## Appeal Decision

**Appeal Ref: APP/R5510/X/24/3338982**

**28 Westholme Gardens, Ruislip, Hillingdon HA4 8QJ**

Existing Front elevation

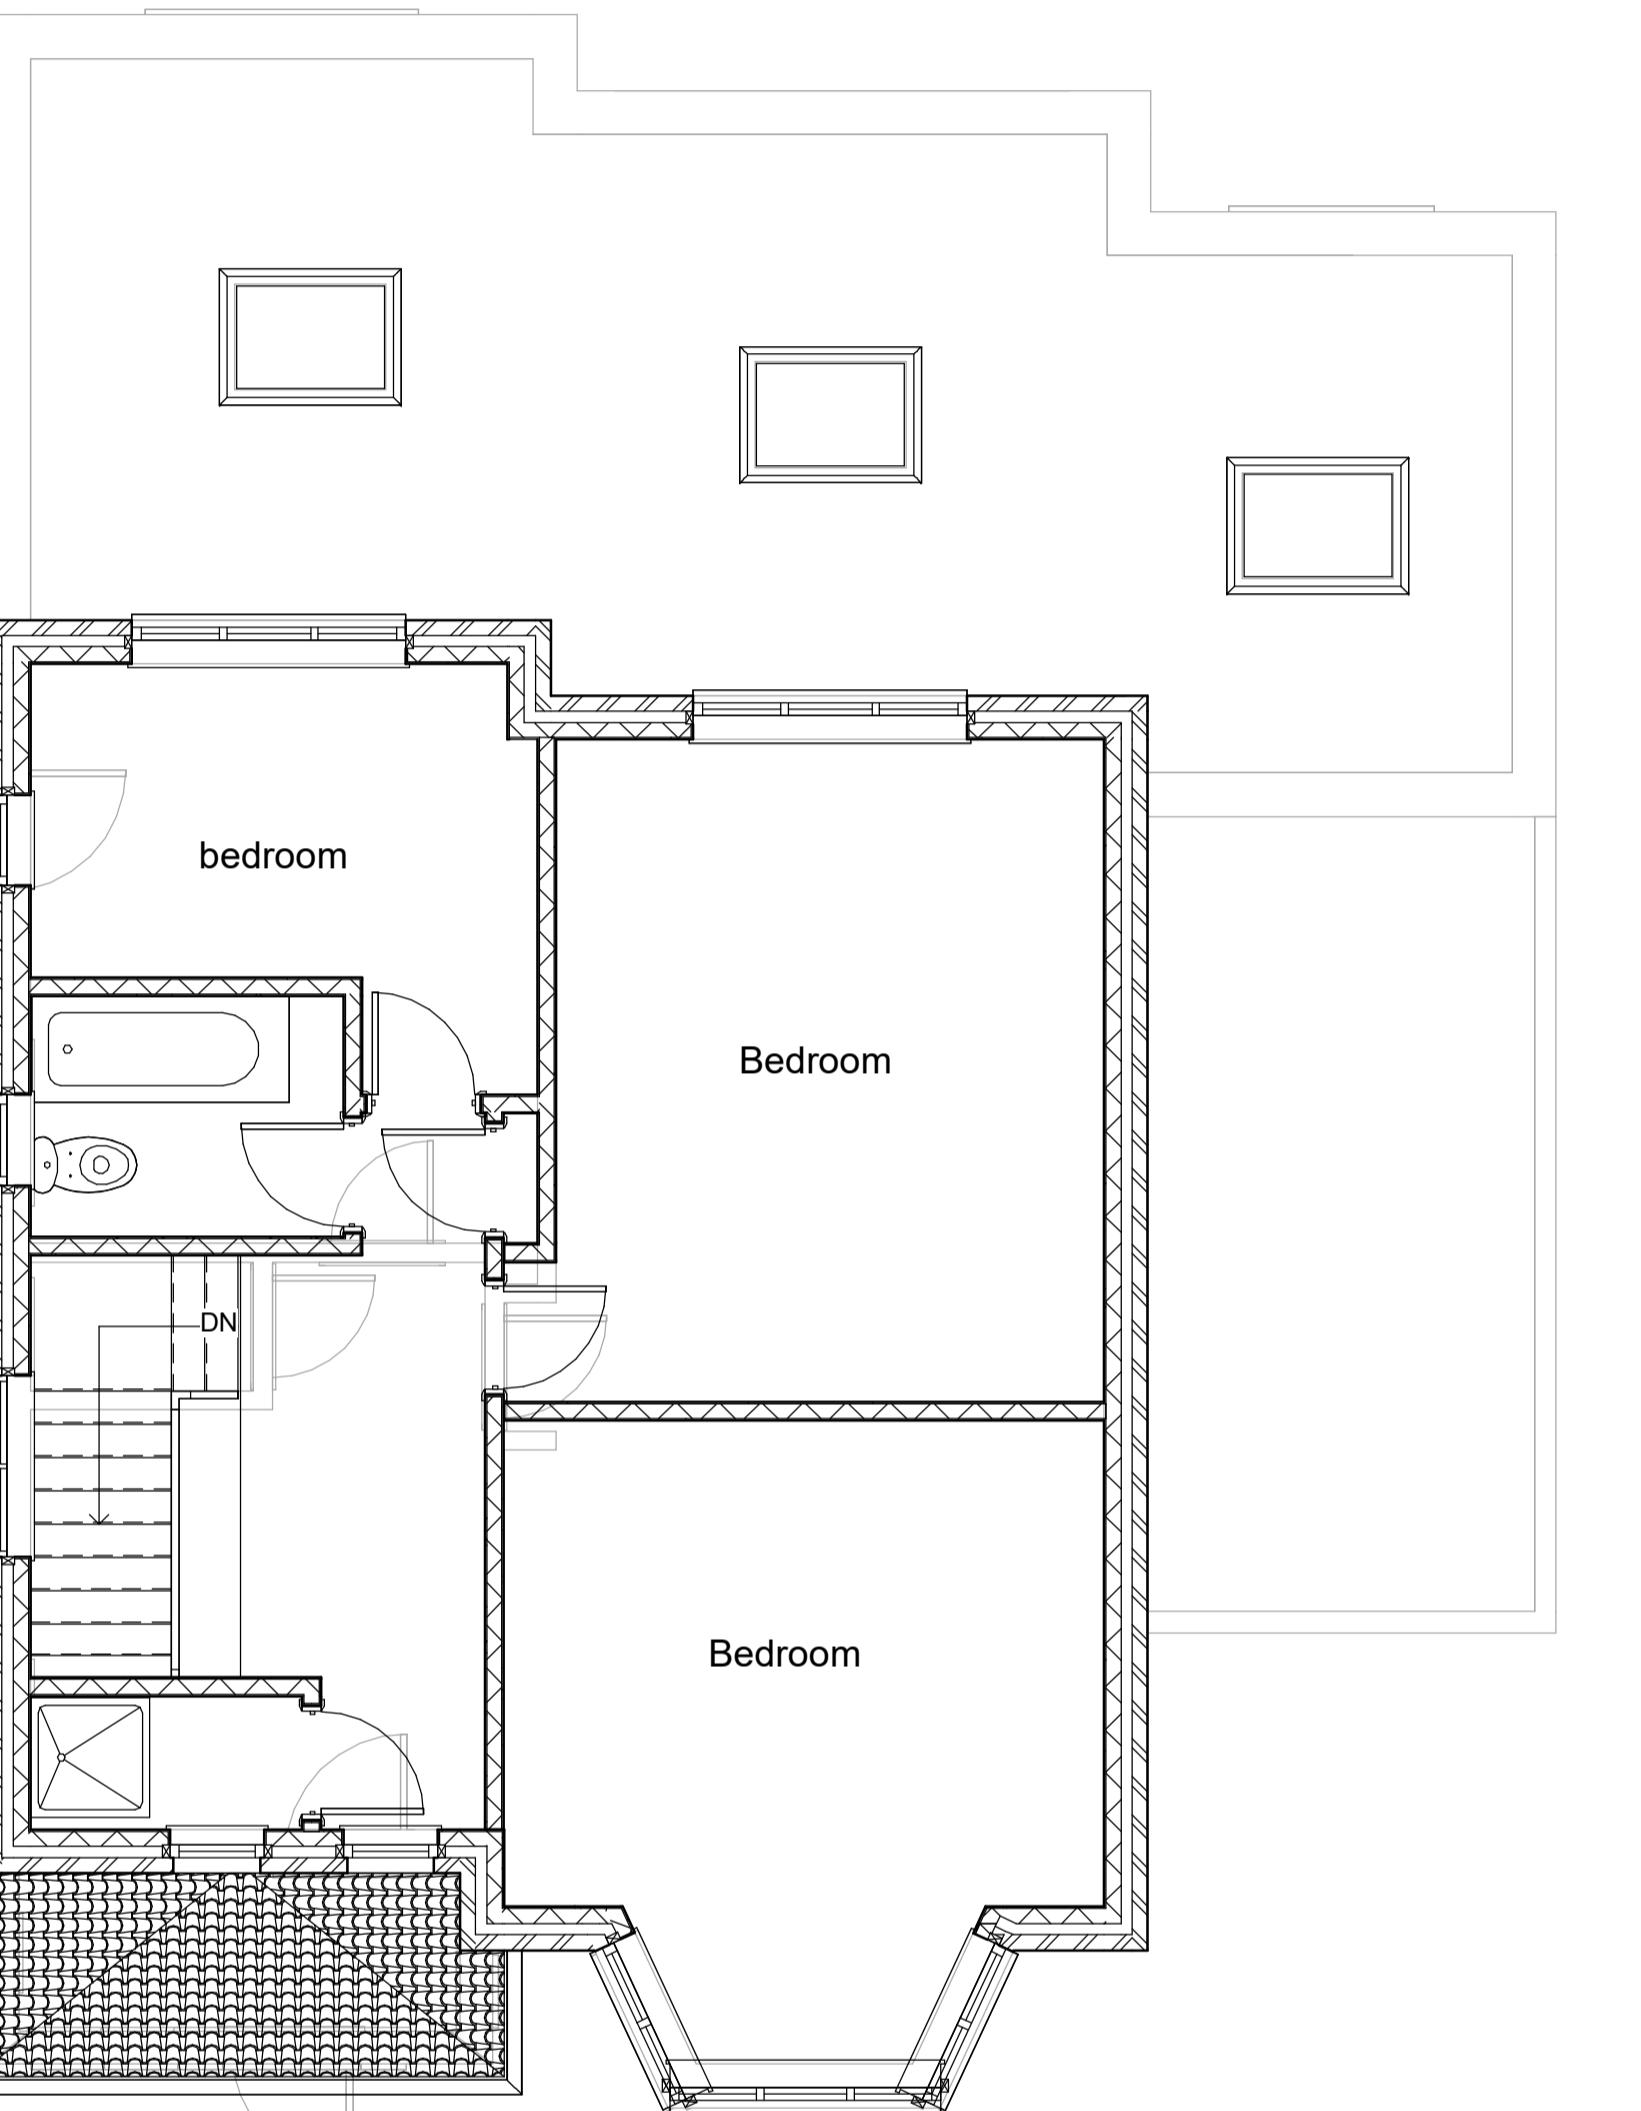
11. Based on the evidence and my observations during my visit, the dwellinghouse is a detached, two-storey, hipped-roof residential property finished in brown brick and white UPVC windows. The existing ‘front elevation’ as shown on drawing reference A101, and viewed on site, includes the front door with side panel windows with a roof over the porch. There are two small first floor windows, but also a projecting bay window feature on the ground and first floors. The property has a hipped roof, which projects outwards in part to cover the bay window feature. There was a hardstanding

area for parking vehicles at the front. The dwelling is set back from, but fronts, at a slight angle, the vehicle highway at Westholme Gardens.

12. In light of the evidence submitted and my observations on site, the 'front elevation' shown on the elevation plans is consistent with the indicators set out in the guidance that define the principal elevation of a property. In this context, the proposed development would result in the hipped roof being converted to form a gable end to the front and rear elevation, together with a flat roofed side dormer. As the formation of the gable end to the front would extend beyond the plane of the existing hipped roof slope, which forms the principal elevation, the proposed development would be contrary to Schedule 2, Part 1, Class B (c) of the Order.
